Consultation Response from KC, Highways Development Management
2020/91918 rear of, 38, Occupation Lane, Dewsbury, WF13 4BP
Reserved matters application pursuant to previous permission no. 2018/93598 for outline application for erection of 3 dwellings
Date Responded:20/08/20
Responding Officer: CNB
Responding Ref:K14-7SE/20

DRG No. CS2/02A SCALE 1:100 @ A1
DRN BY MH DATE 15/04/20

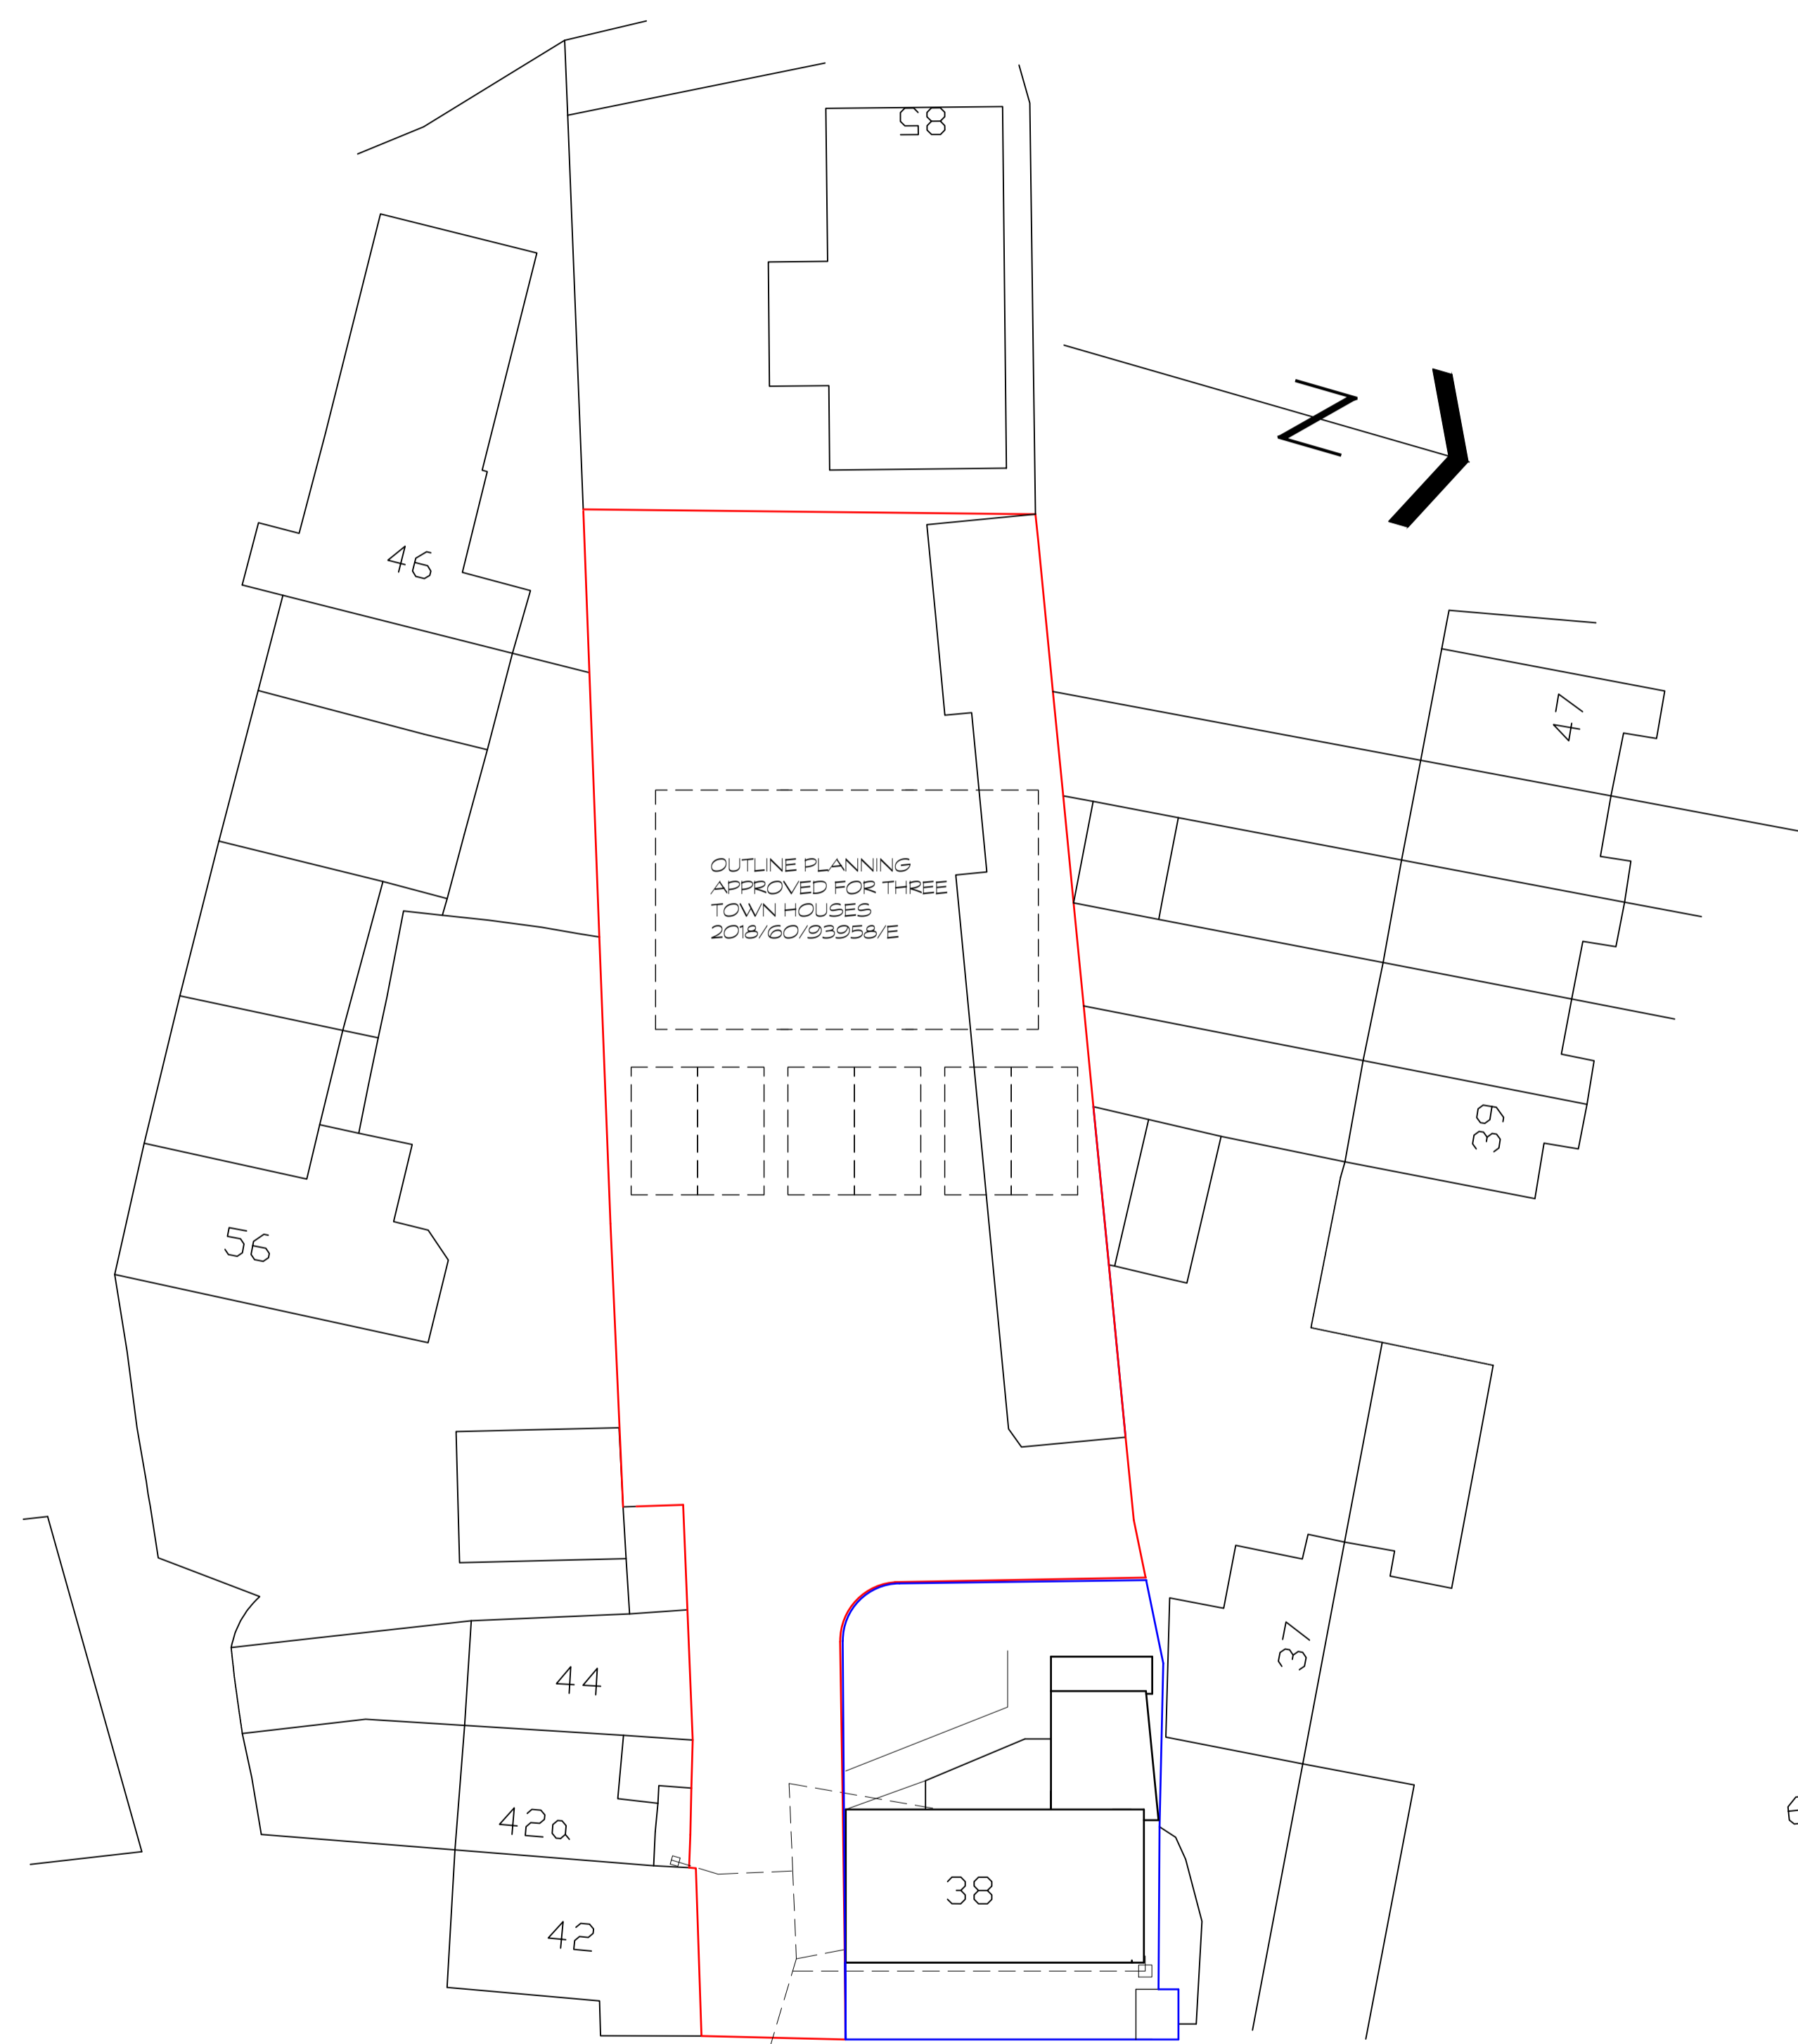
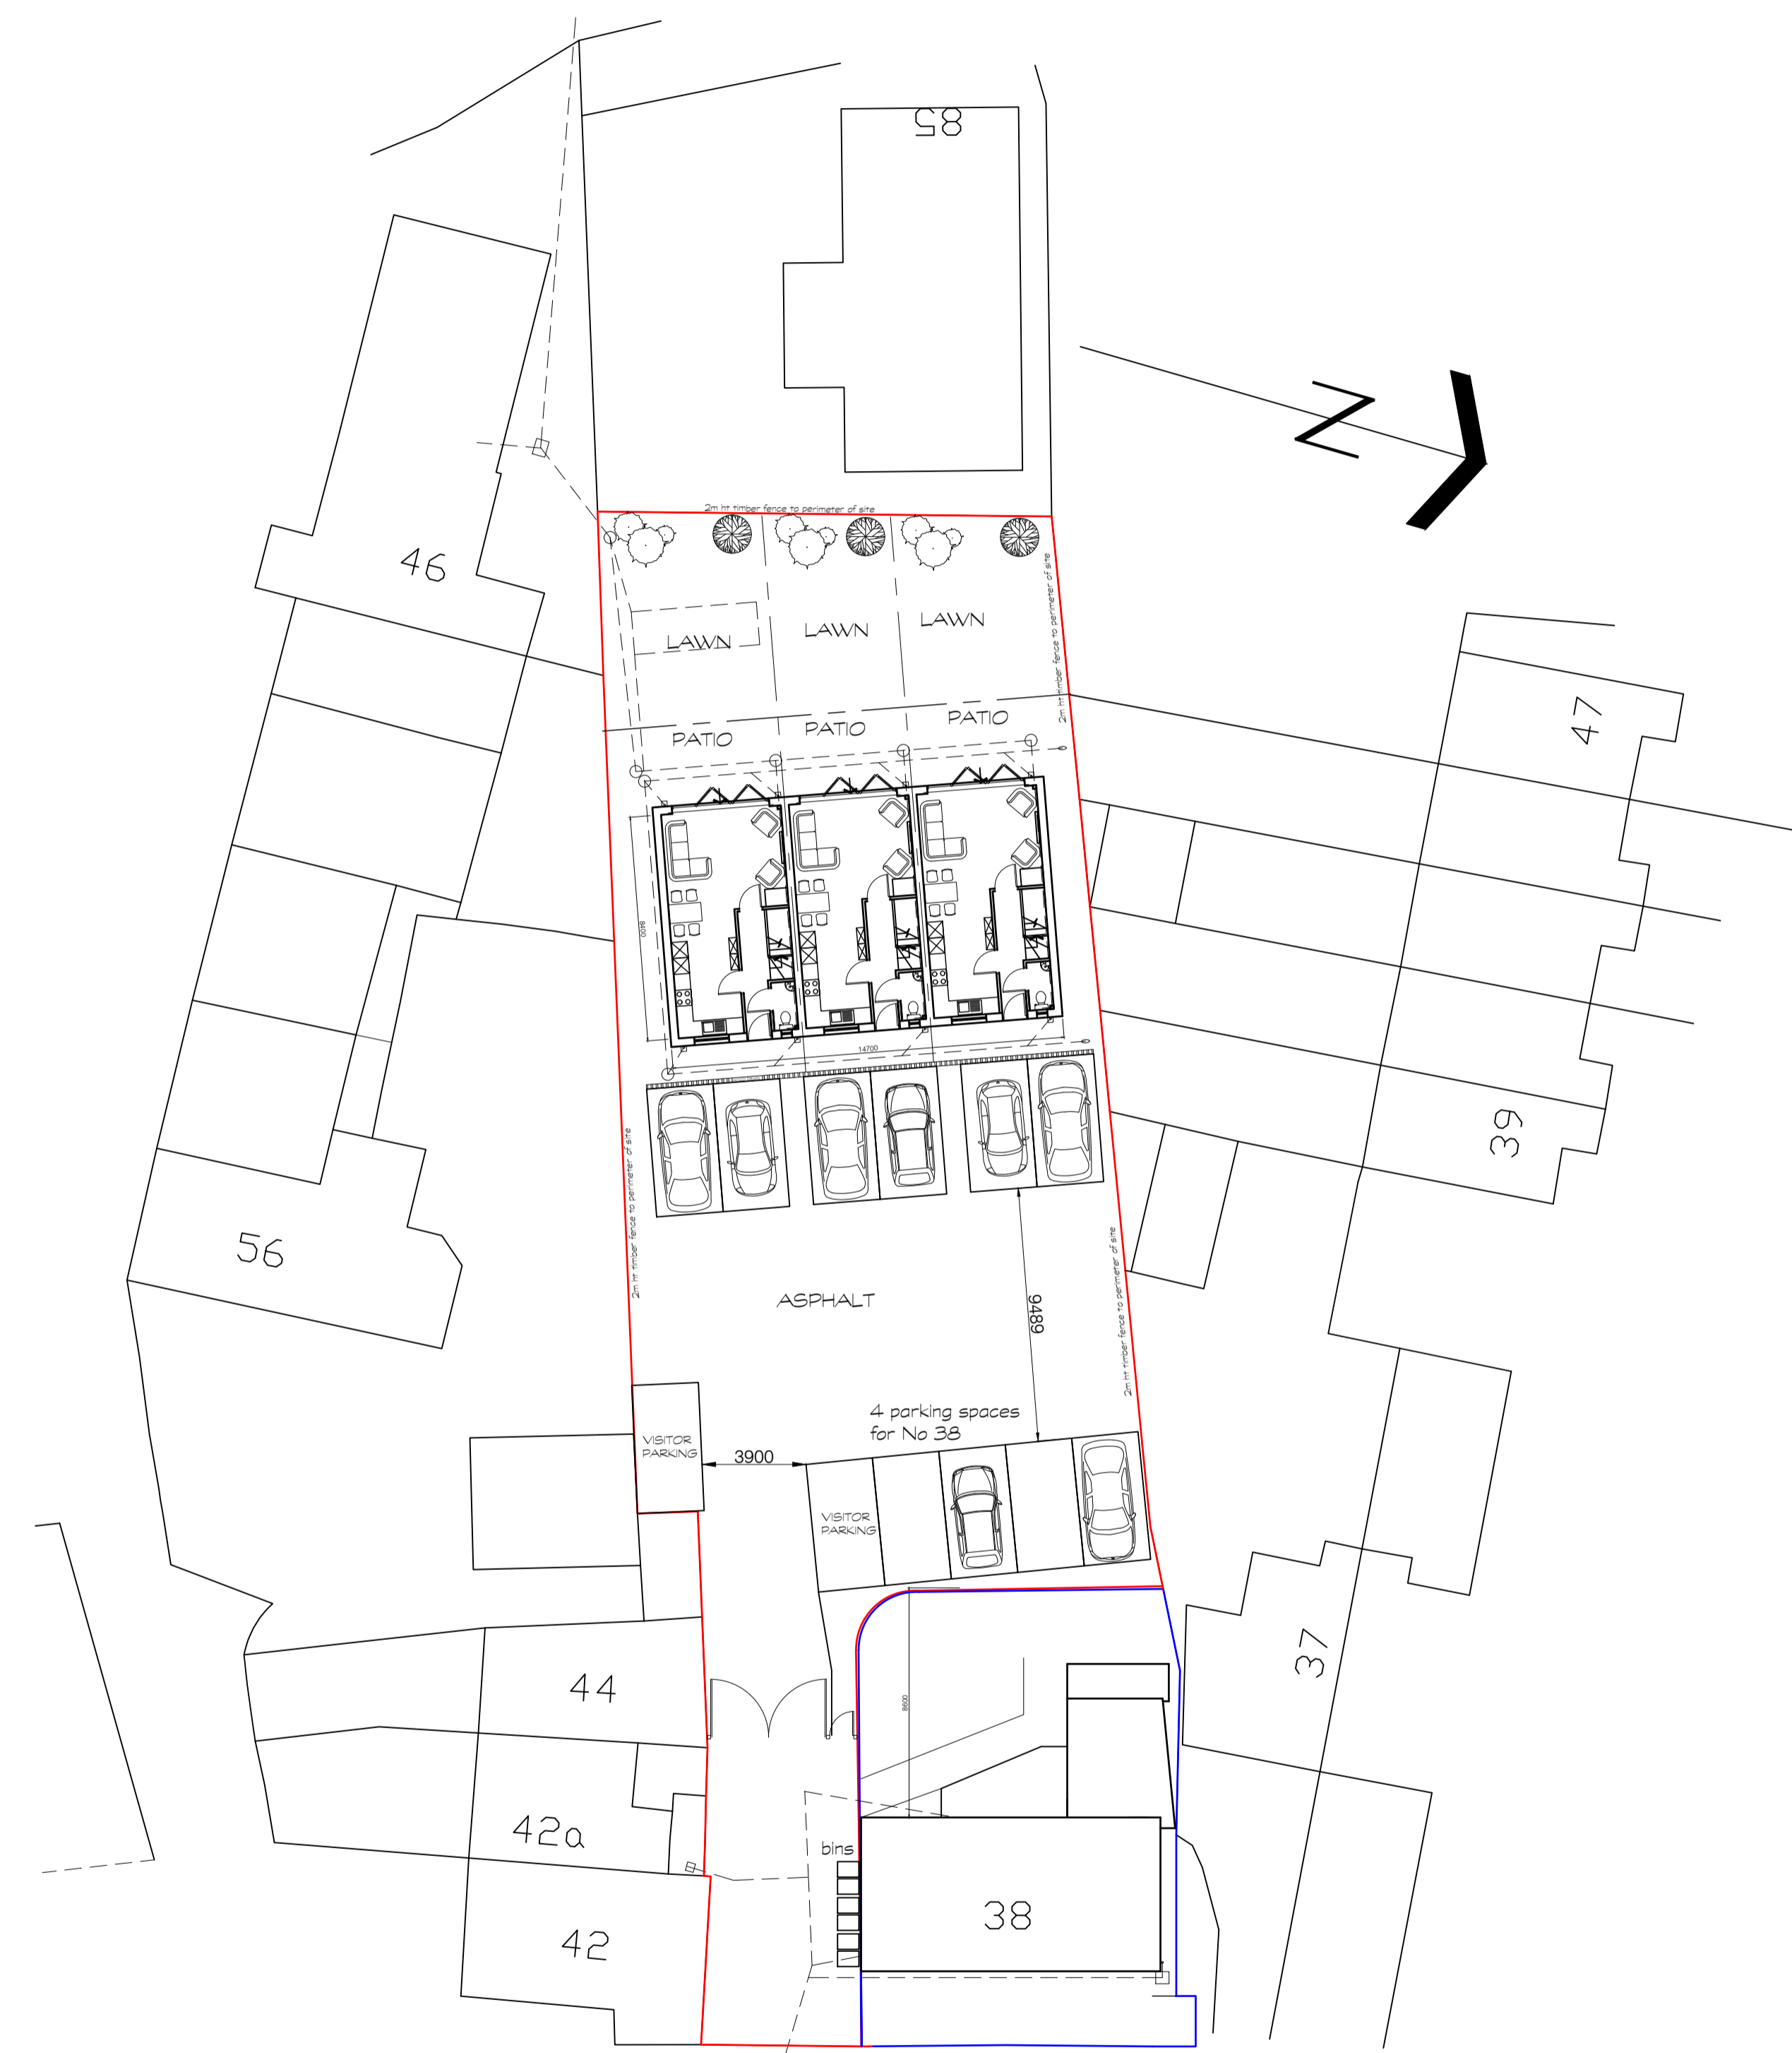
Based on local guidance, the total number of parking spaces required for the combined applications would be 14, three each for the current reserved matters application, four for application No 20/91917 and one visitor space. The number of spaces to be provided is 10, a shortfall of 4 spaces from local guidance. We do not think that the local highway network is suitable for this level of overflow on street parking and so we would request

The bin storage locations shown on drawing CS2/04 are suitable for storage only as they are behind a gate and not accessible to a cleansing operative. We would like to see a collection presentation point indicated on the drawing, this should be in such a location that it is accessible to the collection crew but not where it would obstruct the access or footway or highway for road safety reasons. This should be conditioned.
